AW-48-12-T – 'The White House', 24 Kingsway – 10-4-2012

OBJECTION – AW/48/12/T - Lopping of Conifers – 'White House', 24 Kingsway, Craigweil House Conservation Area and Area of Special Character

Reduce tops of 14 no. Lleylandi trees by a maximum of 3m within the Craigweil House Conservation Area.

The White House 24 Kingsway Bognor Regis

AW/48/12/T

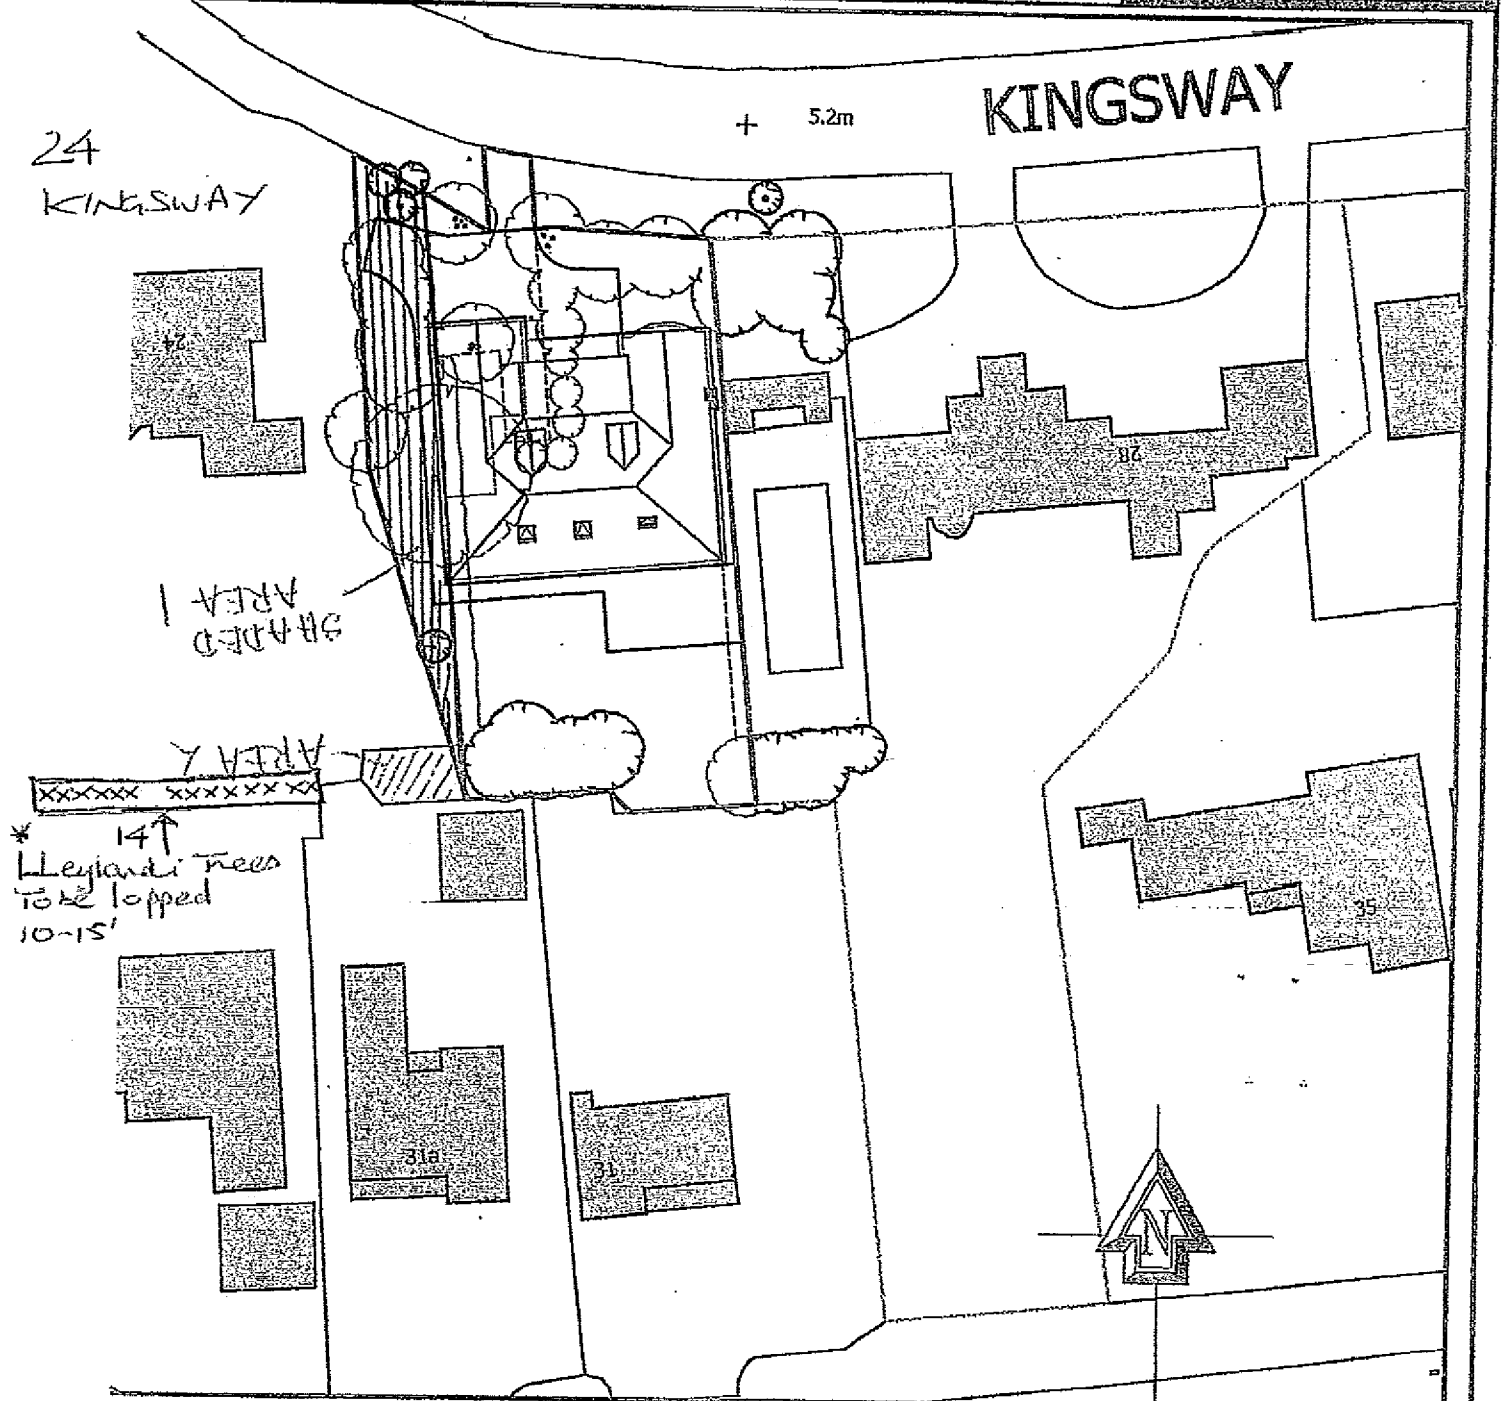
The applicant, who claims no horticultural or arboricultural reason for reducing the height of what appears to be a row of Lleylandii trees, running east to west on the southern boundary of the plot, states only that he requires *'topping of a minimum 10ft of 15 tall conifers in back garden, as stopping light getting into back garden, and also stopping light getting into neighbours garden at the back'*. The attached plan is annotated *'14 Lleylandii trees to be lopped 10-15''*.

In a current application, AW/42/12/T at 31 The Drive, the applicant was required to specify, in metric measure, the exact amount by which he wished to reduce the height of a tree. Surely, it cannot acceptable even to consider this application which says only *'Lopping of minimum of 10ft...'*? That would be a license to fell the tree! And, with some degree of mind-reading, presumably he means 'Topping'! But does he mean 14 or 15 trees. And does he mean 10' or the 10-15' that elsewhere he mentions? Do we really have to guess what this applicant wishes to do to his trees because he fails to make a full and clear disclosure? In the absence of any firm information, we will do our best, while stressing that we consider clarification should be sought.

'need lopping by/of 10 feet minimum' (as stated in Section 3 'Trees Location' of the Application and Section 7 'Identification of Trees') means to the reader, the removal of at least 10 feet of the height of the treeline. It could be misinterpreted as to mean - take the tree height to 10 feet, therefore removing 20 of the 30 feet height. □
